Rosefield Solar Farm development application

Comments by Tom Morrison 28 July 2026

The mistake in Rosefield's application that this note addresses

Drawing number	Revision number	Drawing title	Scale
12.1	01	Agricultural Land Classification	1:19,400 @ A3
12.2	01	Soil Association Map	1:19,400 @ A3

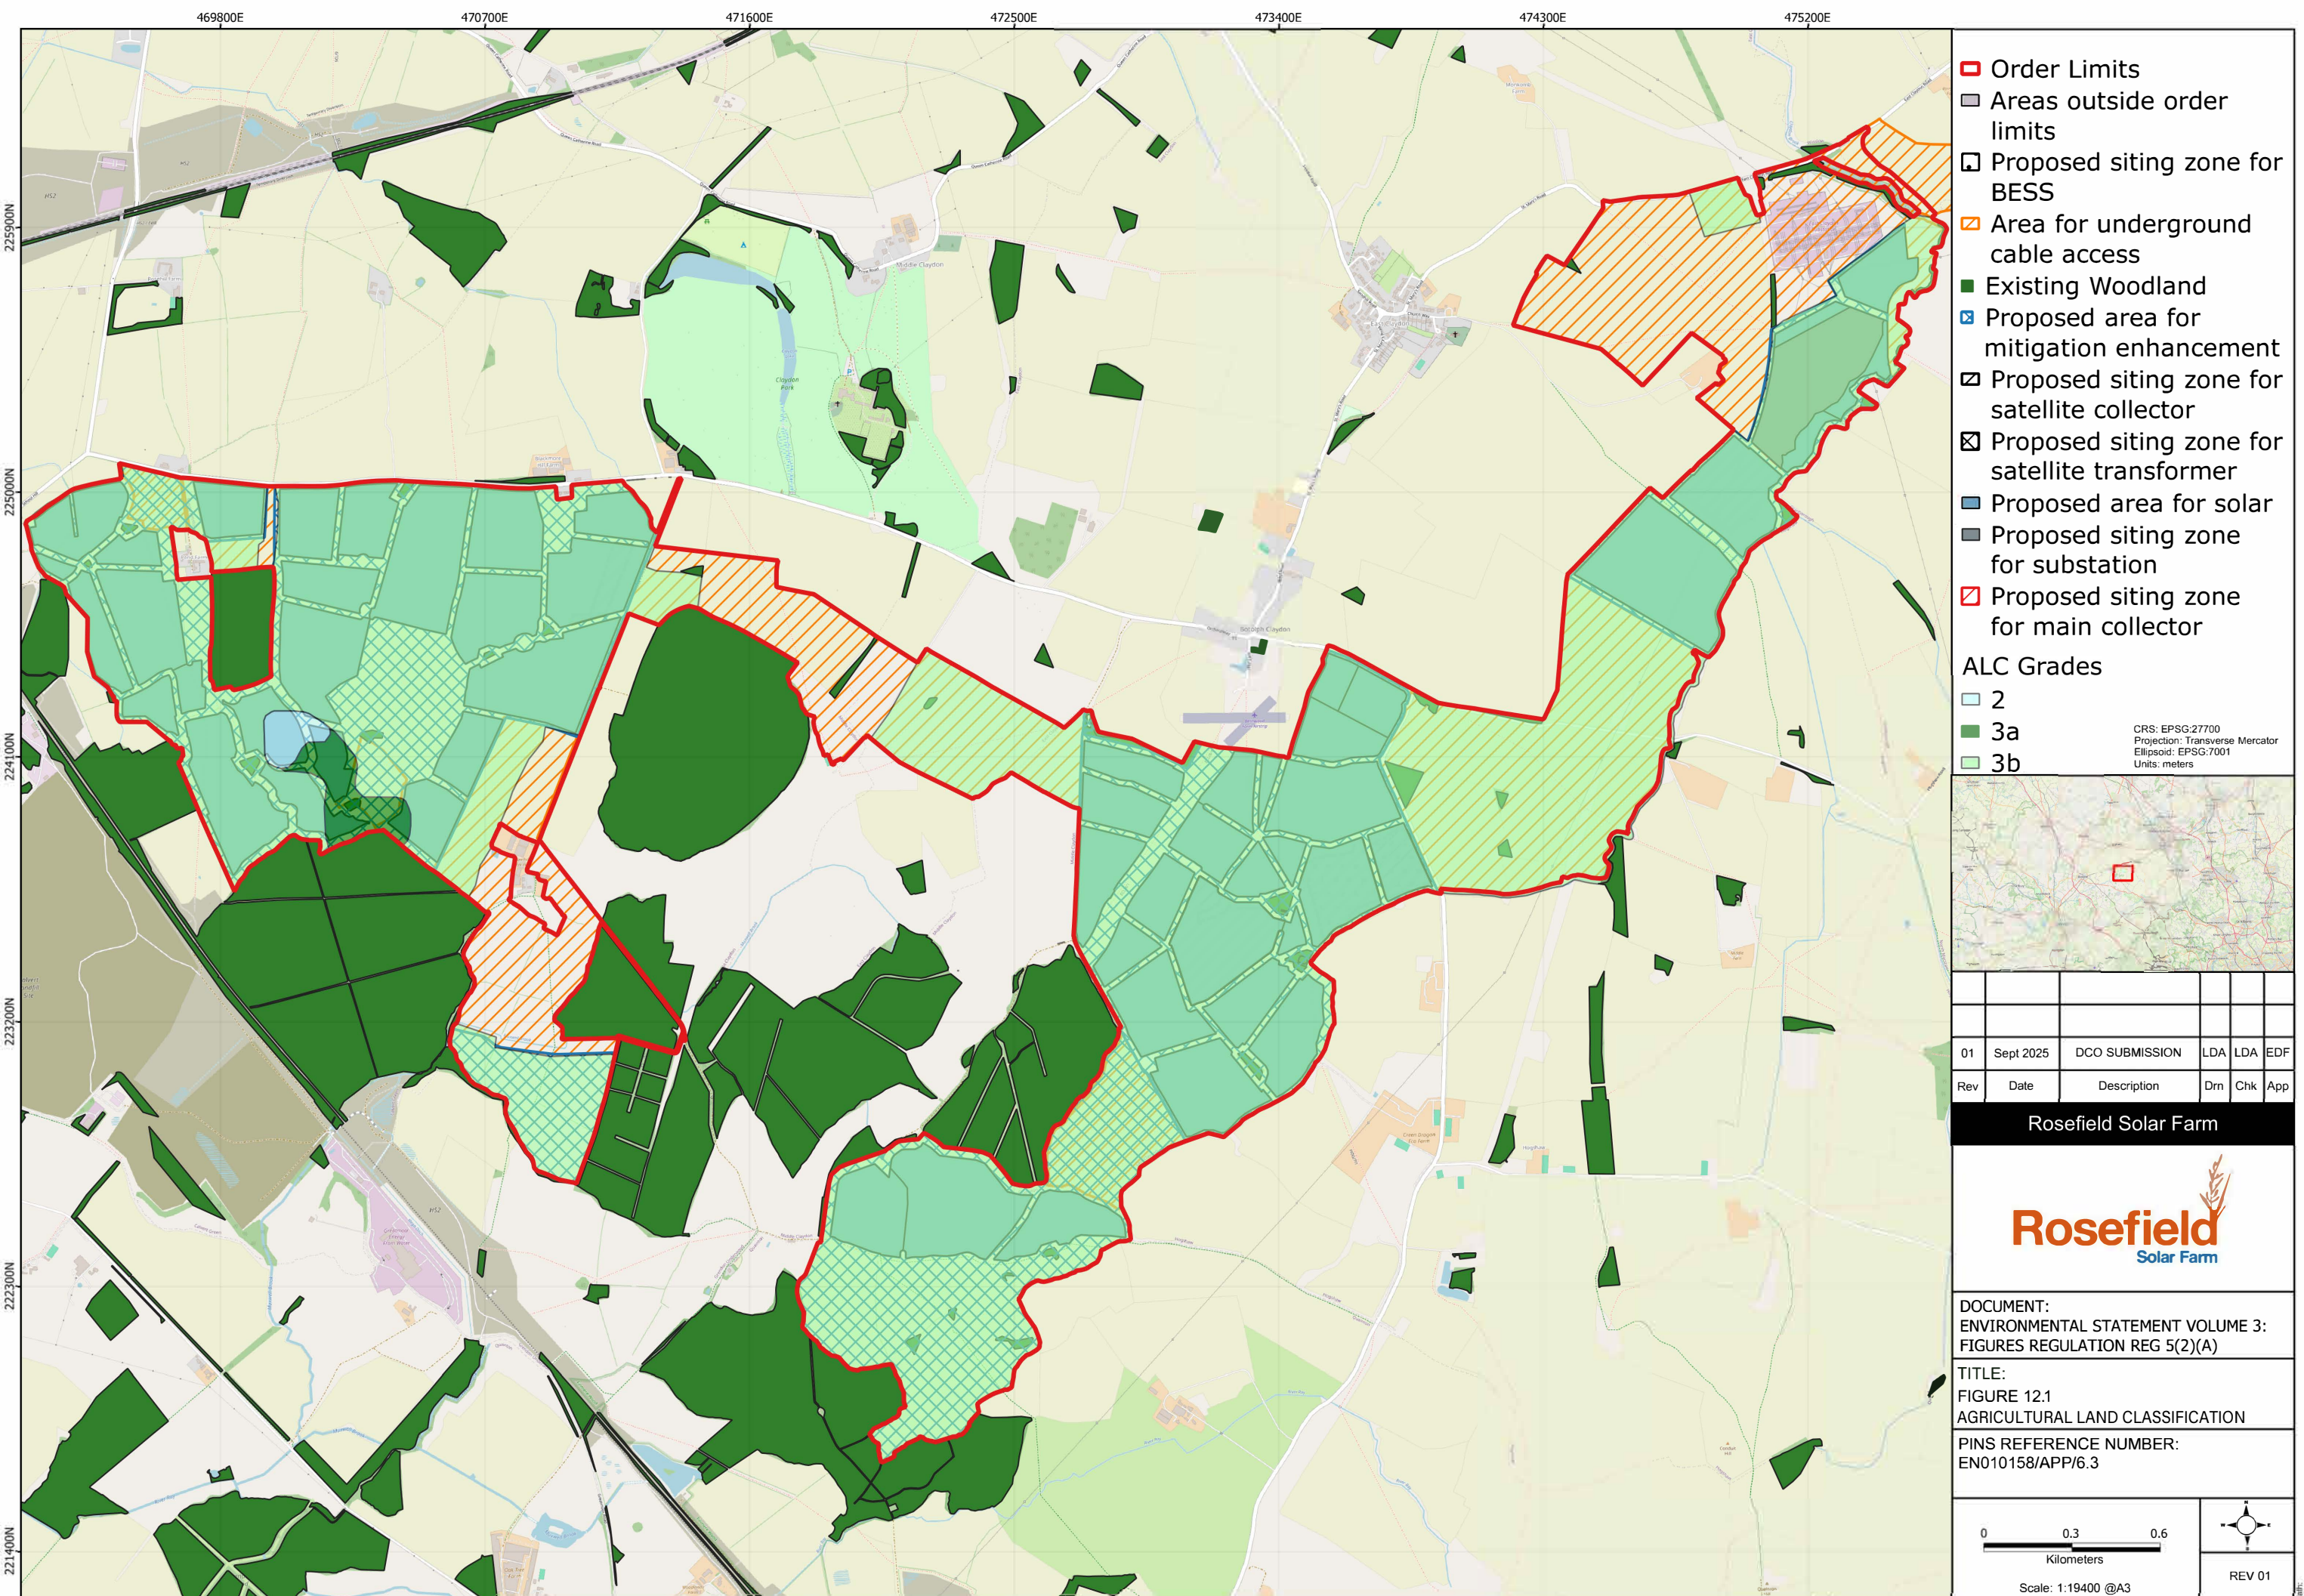
Rosefield's application states that the soils that would be affected by their proposed development are largely infertile and in most areas are Grade 3B.

There is some truth in this. But this Grade 3B classification has been caused by bad farming practices since the 1950s. These bad practices include over-use of nitrogen fertiliser, failure to follow sound crop rotations such as grass fallows with sheep or cattle, excessive use of heavy farm machinery, and over-reliance on the convenience of agro-chemicals.

Before and during the 2nd world war, these soils were largely Grade 3A and Grade 2. The nation (and Hogshaw Hill Farm) understandably drew down in this inherent fertility and was able to grow enough food to feed itself and much of Europe as well after the war. The problem was that in the 1950s we didn't revert to rebuilding that lost fertility. Farmers liked the new way of farming too much. So here we are – excessive flooding, lost biodiversity, over-reliance on “chemical” farming, and a landlord:tenant arrangement which has provided little incentive to regenerate the soils' natural potential fertility. But, to repeat, DEFRA is now robustly encouraging regenerative farming. One doesn't have to be a soil expert or practising farmer to recognise this. Our media are pushing the message strongly. These soils have the potential to return to their original fertility, to Grade 3A and Grade 2.

This mistake in Rosefield's application (one of many, but here I deal with just one) is to take a snapshot of the soils as they are, not what they have been and can be again.

They should ignore the applicant's implication of soil infertility. They should recognise historical and potential soil fertility and balance that against considerations of sustainable national food security.
